KITTITAS COUNTY

MEMORANDUM

SUBJECT: Anderson Short Plat SP-10-00013

**ANDERSON SHORT PLAT
 PART OF SECTION 33, T. 18 N., R. 19 E., W.M.
 KITITAS COUNTY, WASHINGTON**

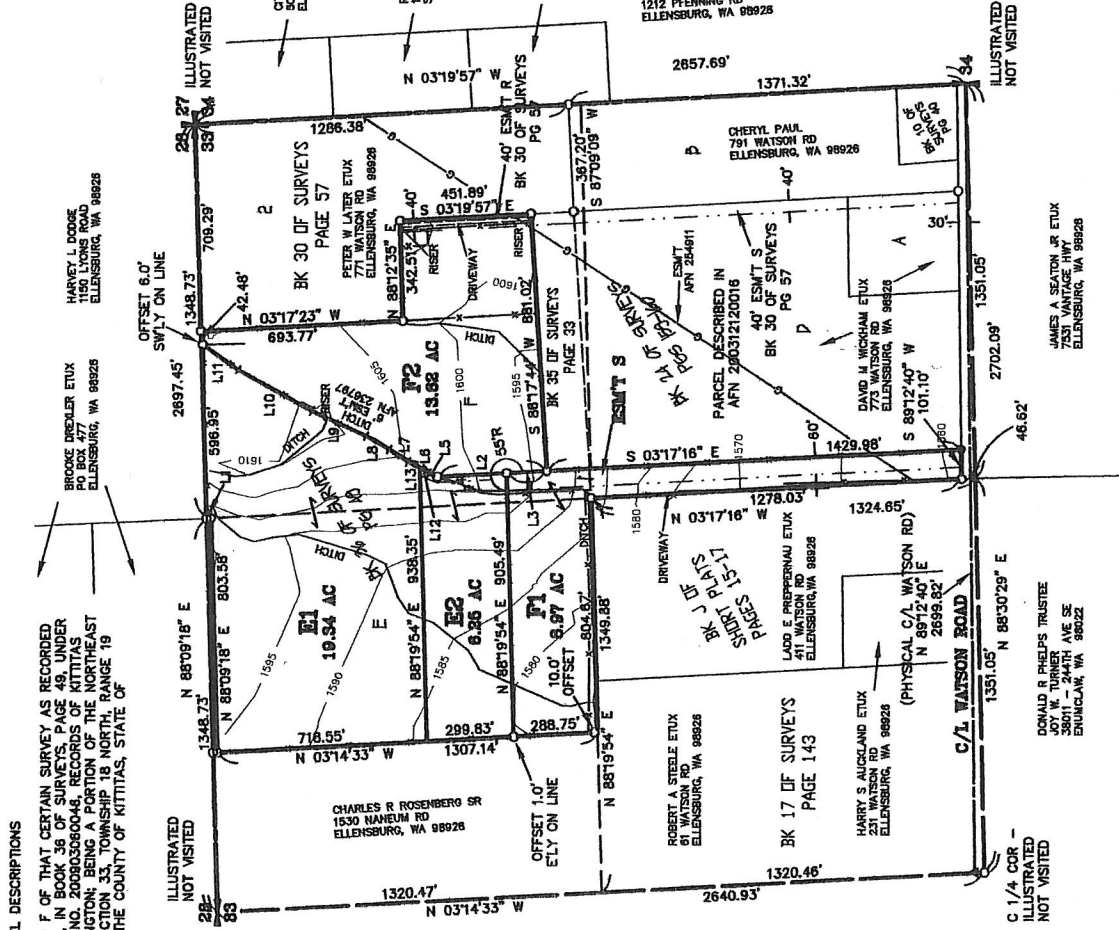
3. Lot E1 Access: The easement serving lot E1 shall be clearly identified on the face of the plat.
4. Private Road Improvements: Access shall be constructed as a Low-Density Private Road. See Kittitas County Road Standards, 9/6/05 edition.
